RESPONSE REPORT

PROPOSED SUBDIVISION

NORTHBANK ENTERPRISE HUB

TOMAGO ROAD, TOMAGO

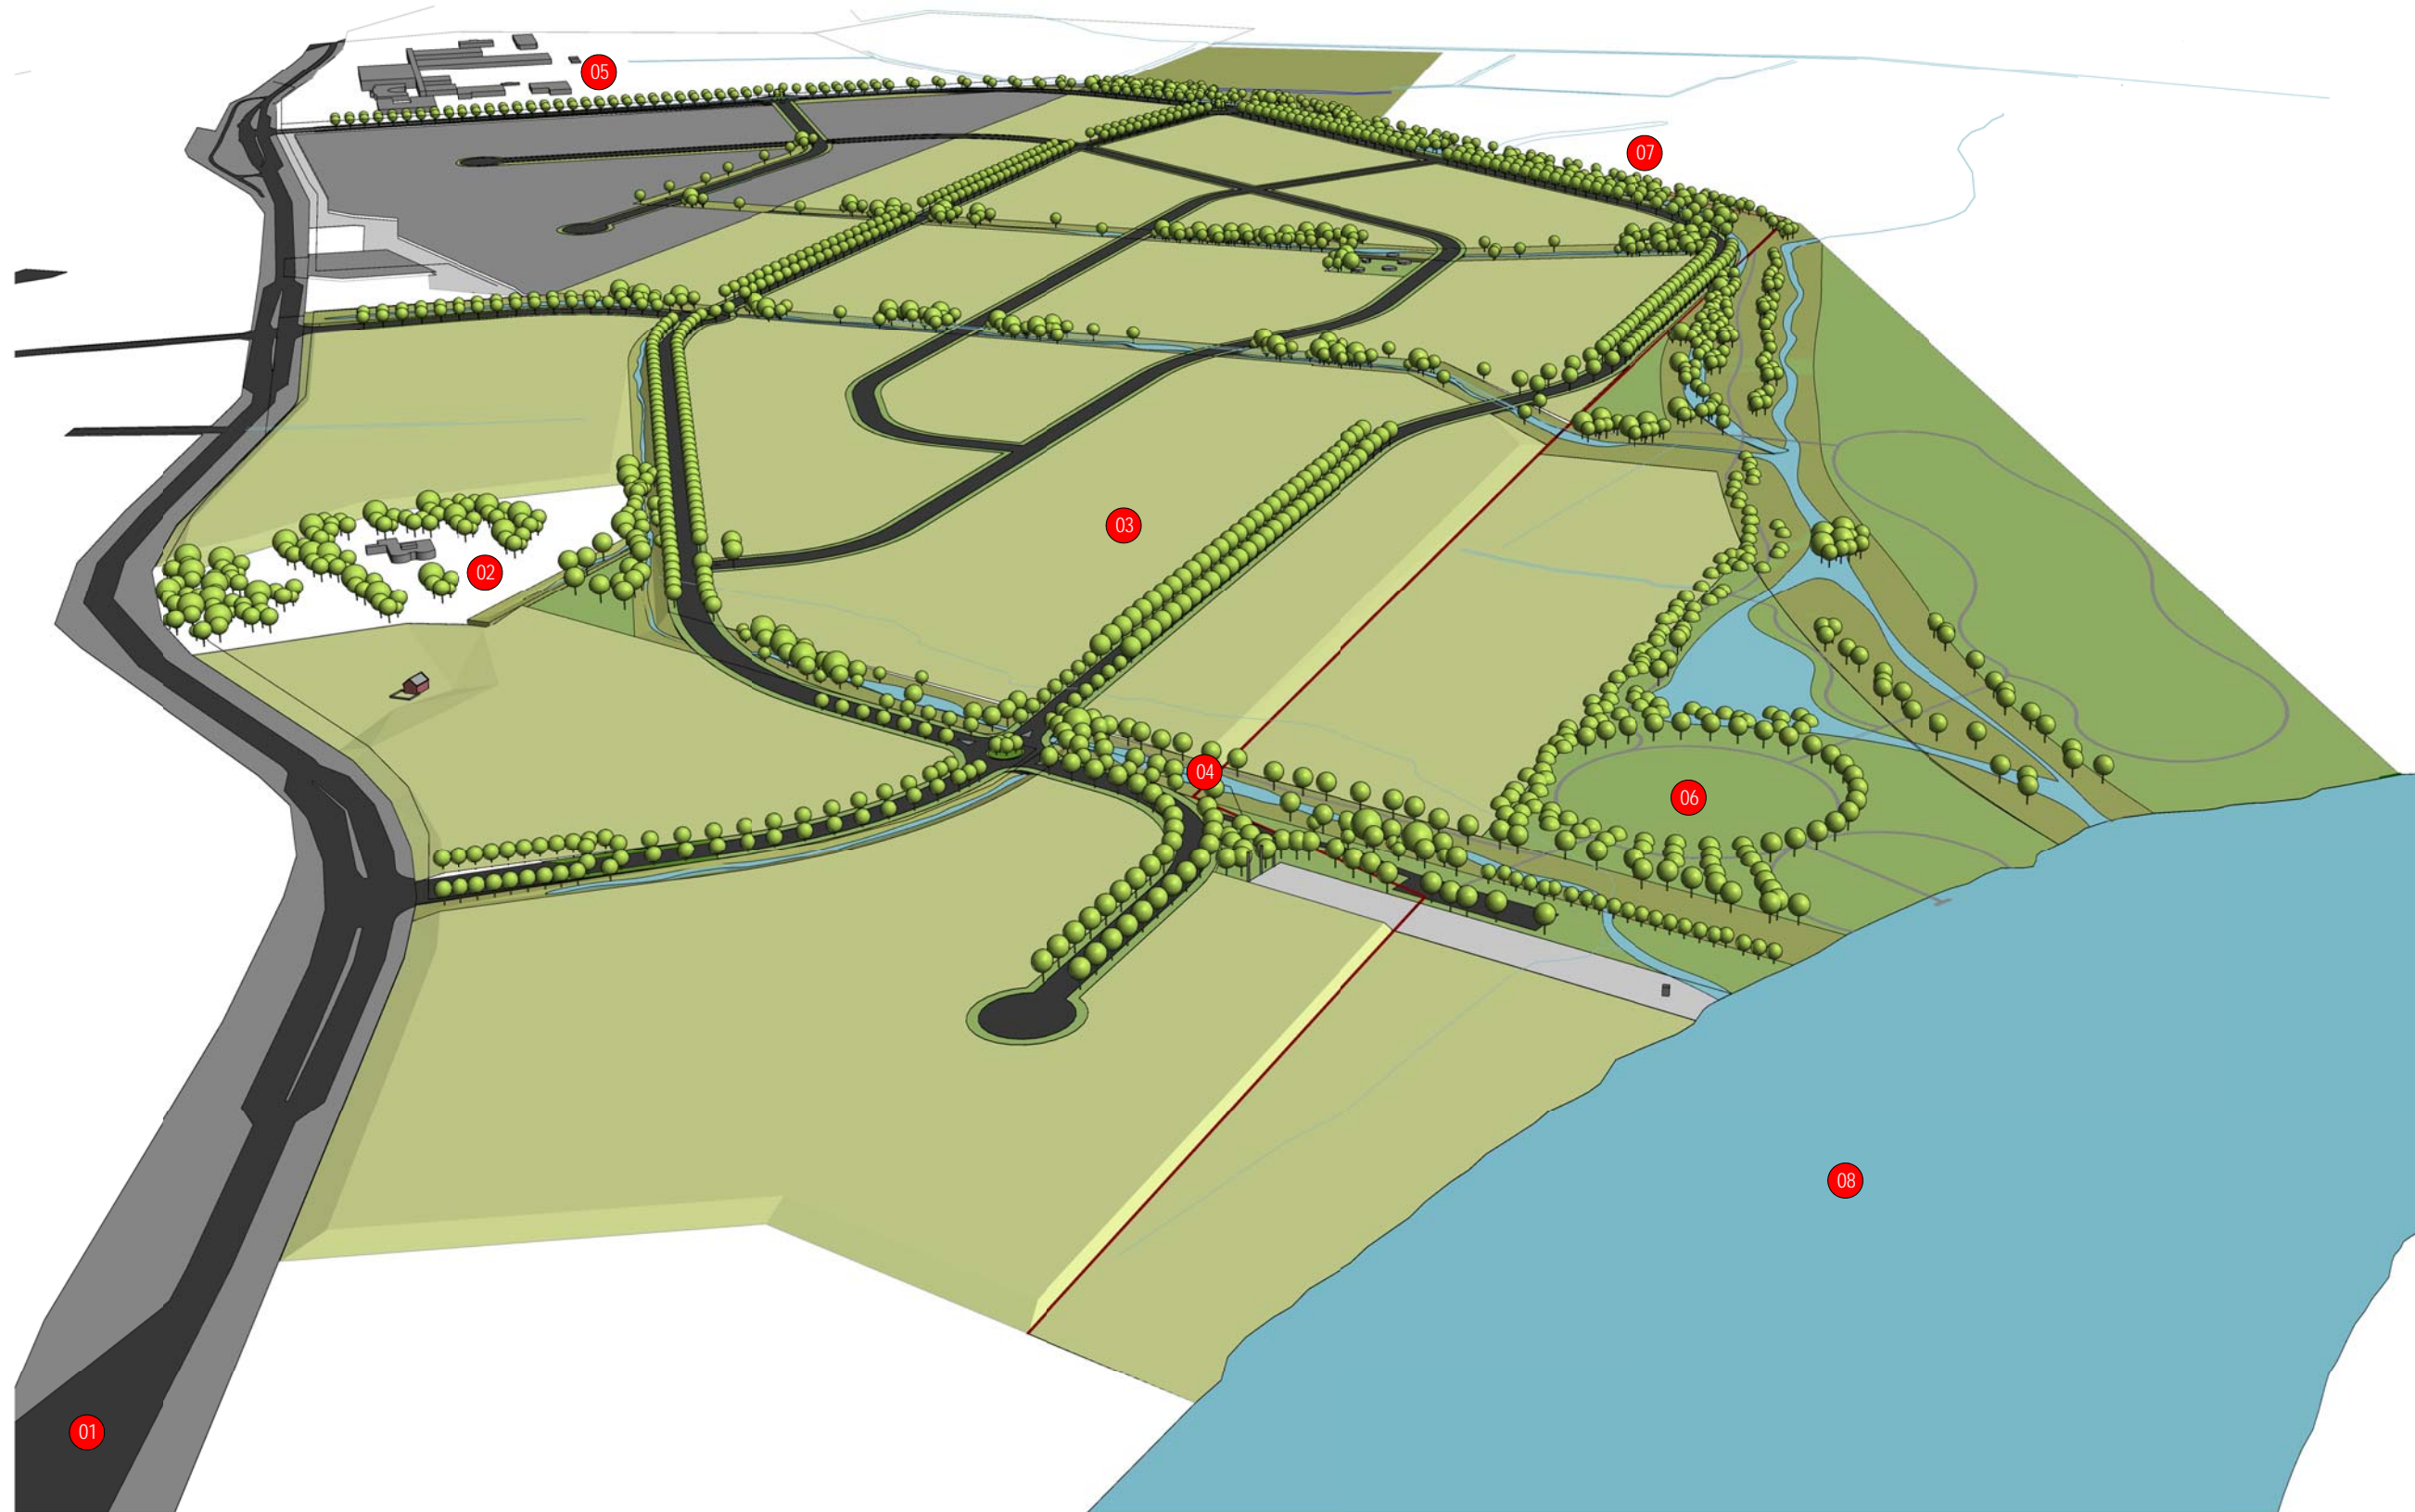
- The proposed internal road system shows block lengths well in excess of Council's Development Control Plan requirements. These long blocks will require some form of speed management to ensure a suitable speed environment, to enable safe access to properties within the subdivision and safe operation of the intersections.

- Several of the internal intersections are shown as 4-way intersections. These will need careful design and prioritisation by regulatory signage to ensure safe operation and compliance with relevant Australian standards.

The site layout at this point in time is seen more as the conceptual base for the overall site rather than a base for specific lot detail.

The area for development is expansive and will be a staged development; as demand is identified and the development site expanded the tenants or purchaser's requirements will be identified.

The current site layout provides a wide view of the core road network however demand for smaller lots may deem intermediate minor roads eventuate to service a smaller lot size demand.

Therefore TPK submits that flexibility within the site remains but that Council's comments on block length are acknowledged and will be resolved as lot size detail emerges.

The first intersections into the estate from all three access intersections are proposed on the site layout as roundabouts hence priority/control is established.

The current site layout has four other cross intersections further into the estate and one is also proposed for roundabout control. TPK acknowledge that the priority route is not identified in plans at the other three and suggests E-W be adopted as the priority routes.
